KITTITAS COUNTY

MEMORANDUM

TO: All Staff
FROM: Public Works Plan Review Team
DATE: January 5, 2026- UPDATE January 27,2026
SUBJECT: BL-25-00024 Haberman-Tirey

RECORD OF SURVEY

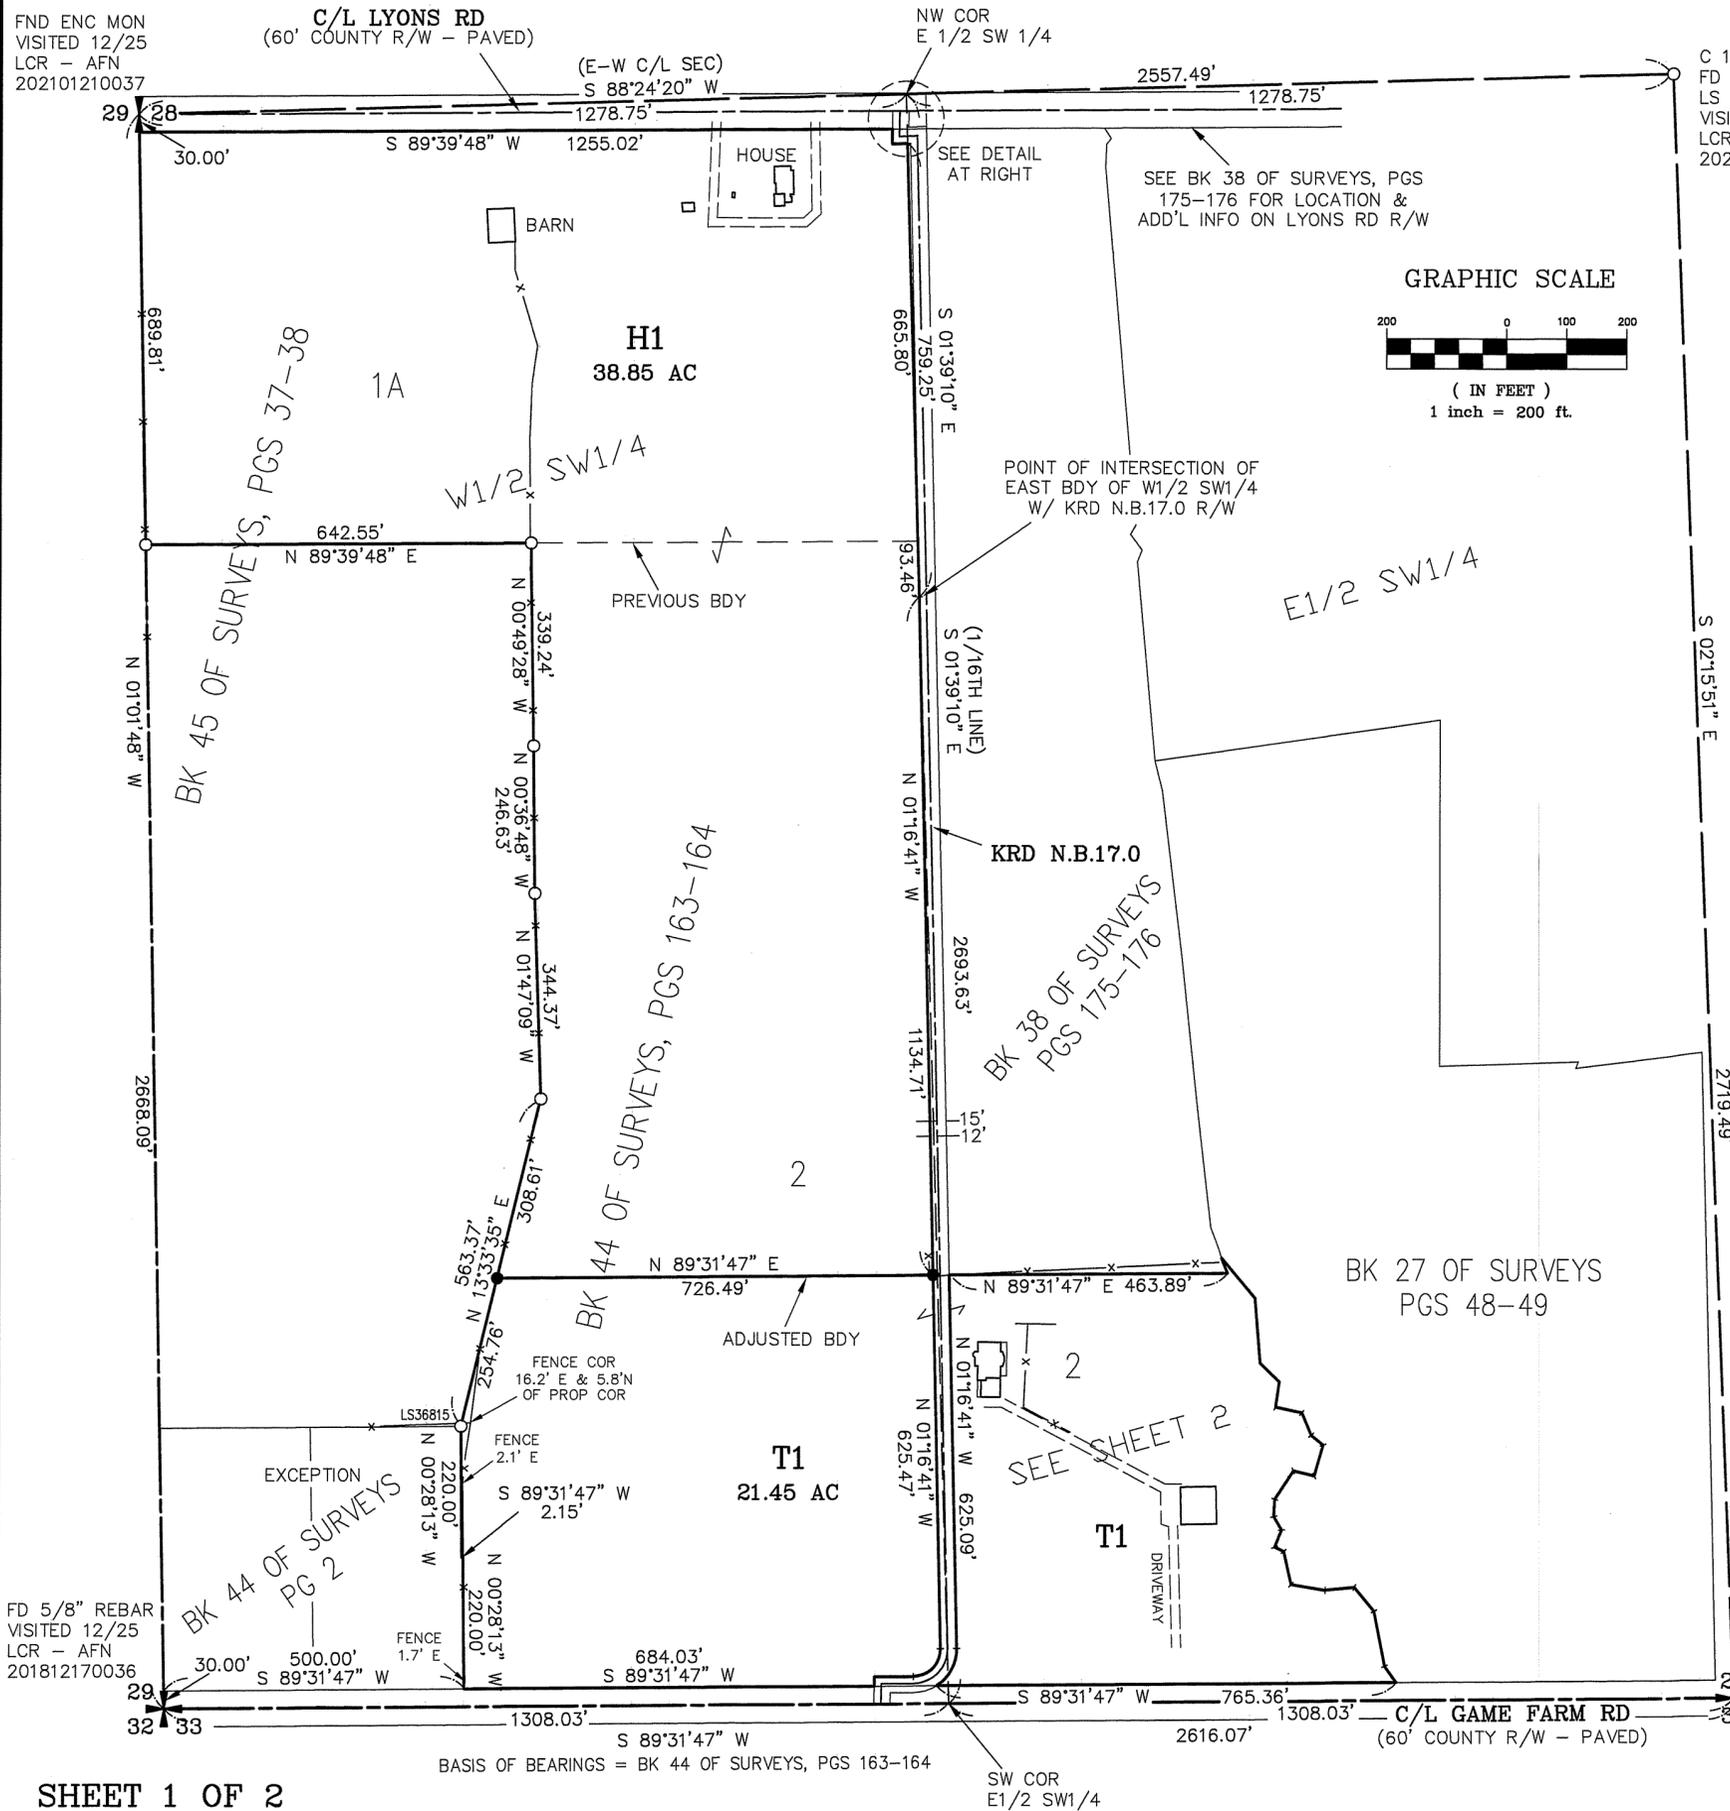
SURVEY	As the application does not contain a survey map, comments are herein reserved until final review. (JT) UPDATE 01/27/2026 1. The aerial image for proposed Parcel H1 has a pond located near the south boundary. Please show this pond, or confirm it is no longer there. (JT)
TRANSPORTATION CONCURRENCY	No transportation concurrency requirement for this project. (RC)
FLOOD	A portion of parcel # 17648 is mapped within a FEMA identified special flood hazard area (1 percent annual chance flood zone). All development within the floodplain must be permitted through the floodplain development permit process and follow the regulations within KCC 14.08. While not required by KCC 14.08.220, it is highly encouraged that the floodplain boundaries are outlined on the face of the recorded survey. (SC)
WATER MITIGATION/ METERING	No comments. (SC)
AIRPORT	No Comment. (RC)
